Article 21 of the Town and Country Planning (General Development Procedure) Order 1995
Application for approval of details reserved by condition 2 and 3 of planning application BR/119/09
24 West Street Bognor Regis,,

Arun District Council have decided to **REFUSE** details reserved by condition for the **following reasons:**

Profile combination & drainage positions

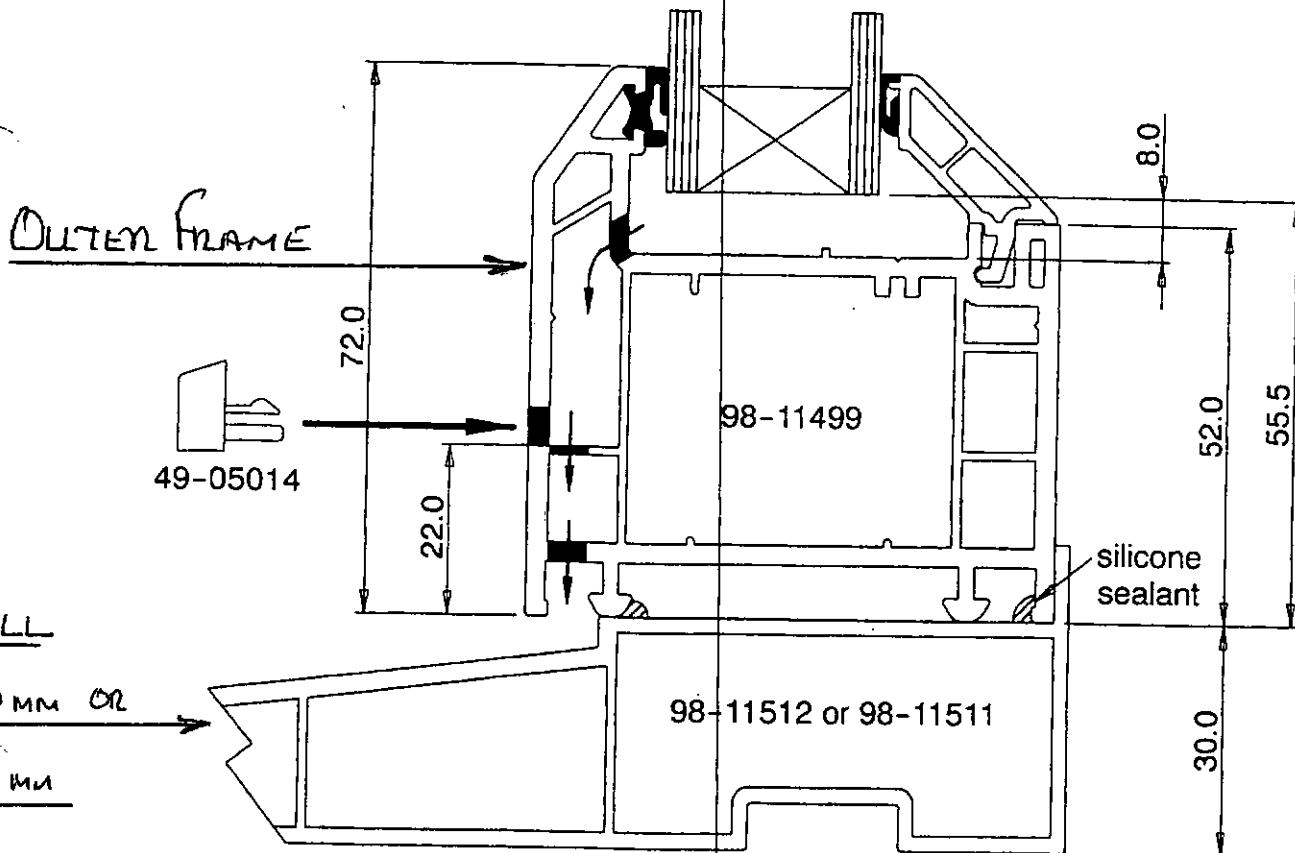
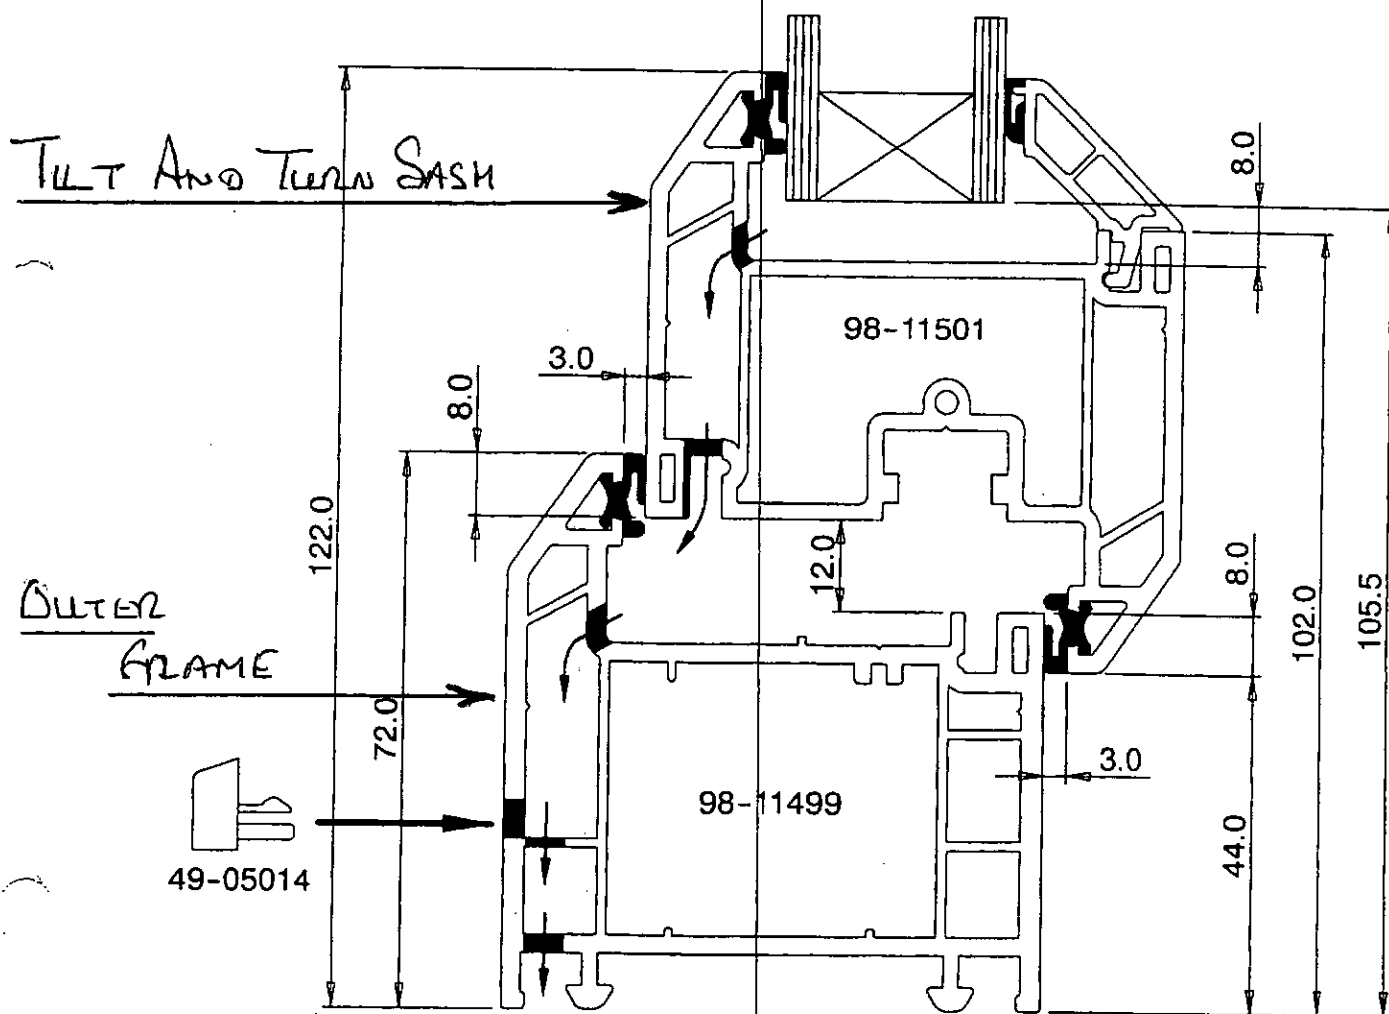
The sample that you have submitted proposed to be used as the finish for windows and doors is not considered to be acceptable. The application has been refused because plastic is not considered to be a material that will assist to preserve and/or enhance the character and appearance of The Steyne Conservation Area.
